CITY OF ALBUQUERQUE

**Re: Gillani Residence, Grading and Drainage Plan
Lot 10, Block 1, Tract 3, Unit 3, NAA
8800 Modesto Ave., NE
Engineer's Stamp dated 9-30-13 (C20/D068)**

Based upon the information provided in your submittal received 10-03-13, the above referenced Grading and Drainage Plan cannot be approved for building permit based on the following comments:

GRADING & DRAINAGE PLAN

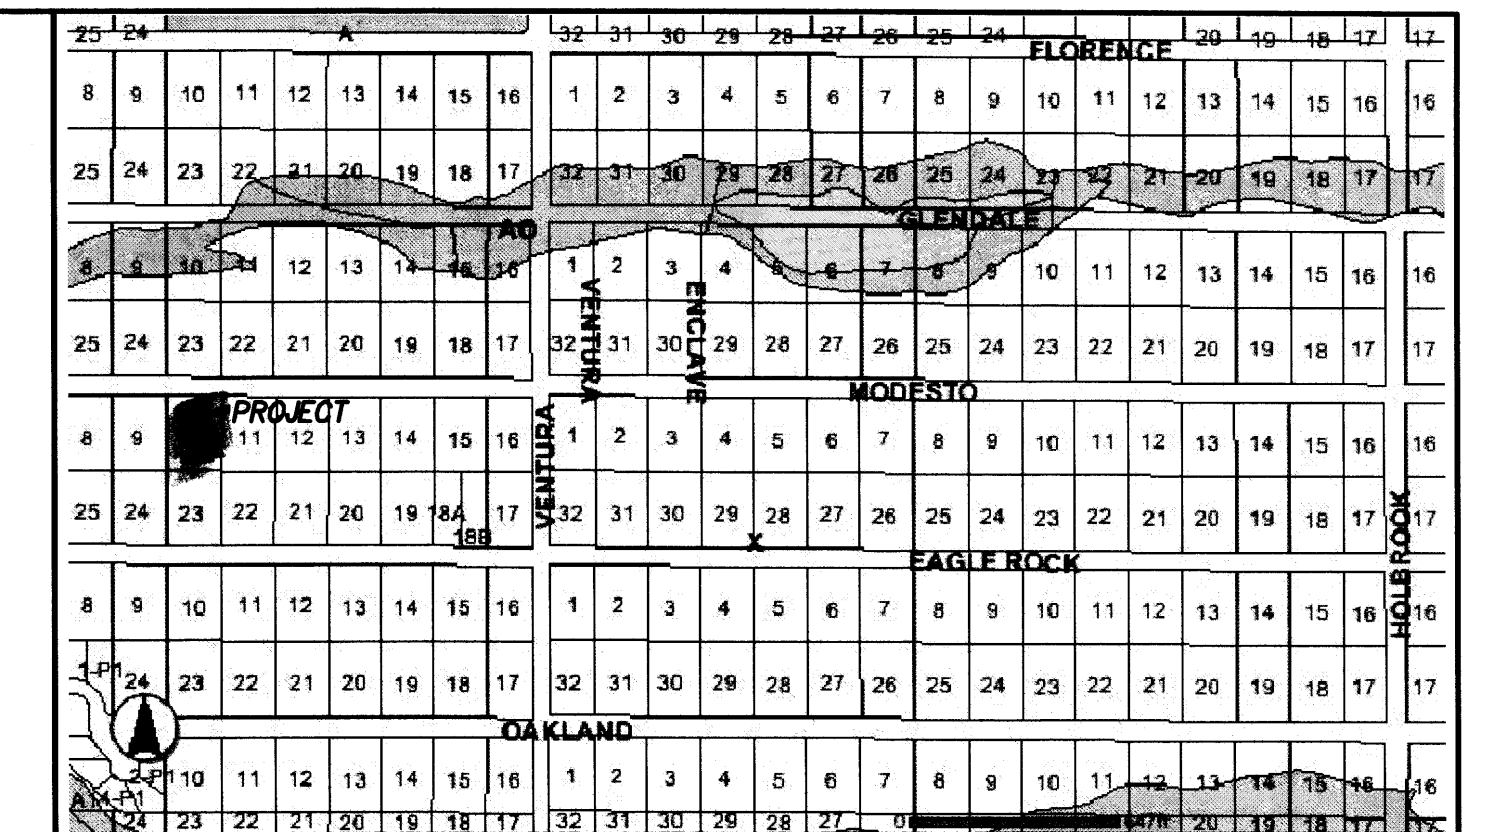
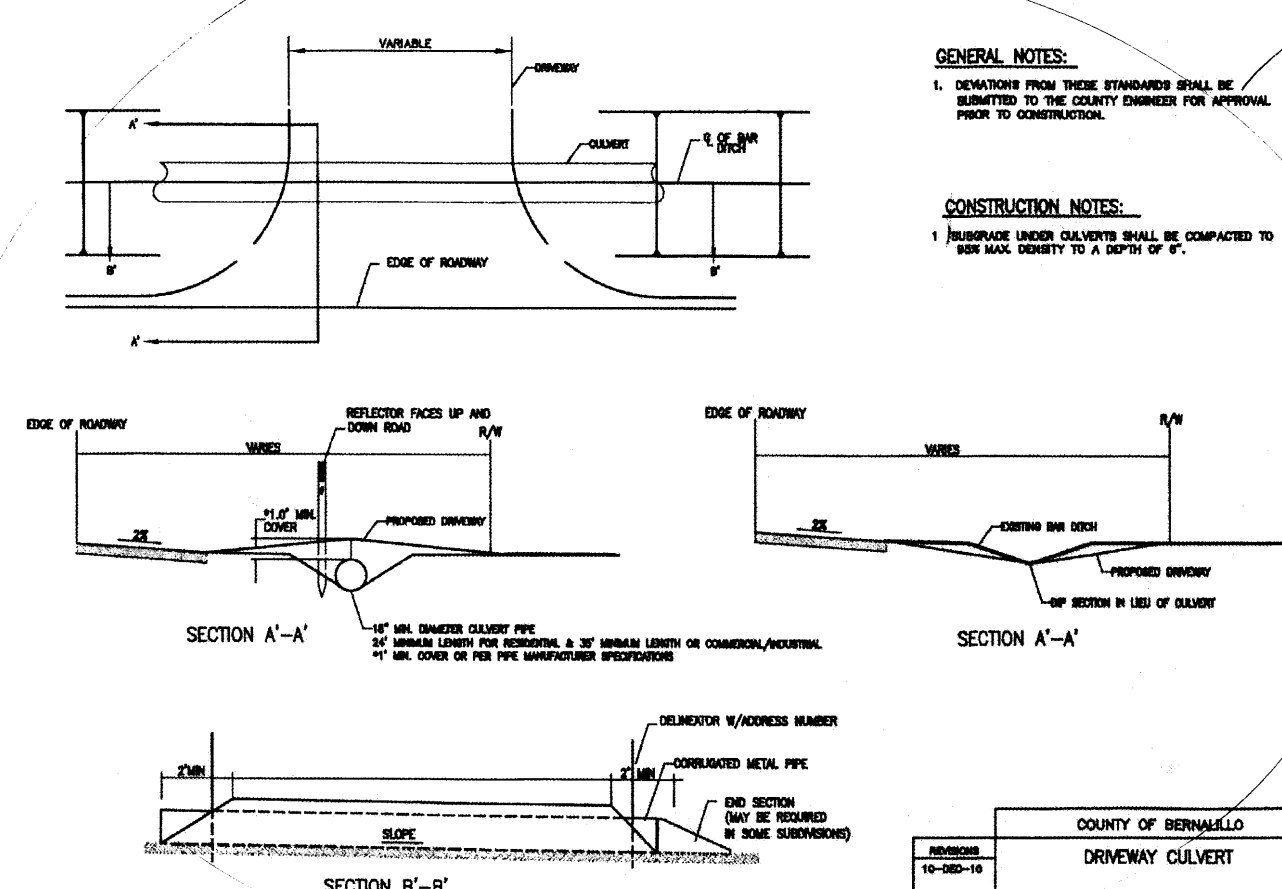
- The contractors in most cases grade/disturb the entire lot. Therefore, under developed conditions land treatment A should be zero. Please also double check land Treatment D.
- Provide an offsite basin map. How much runoff will be draining through the 18" CMP proposed in the road?
- Provide culvert capacity calculations for all the pipes. Is the swale north side of the property sized adequately to carry the offsite runoff from the east?
- Provide detail elevations for the entrances and the culvert crossing. Please include edge of the asphalt along Modesto and top of culvert elevations.
- Provide riprap at the outlet of the pipes.

- Carry the offsite runoff from southeasterly portion of the lot to the north to Modesto in a swale and avoid building additional culvert and improvement in front of the Garage.
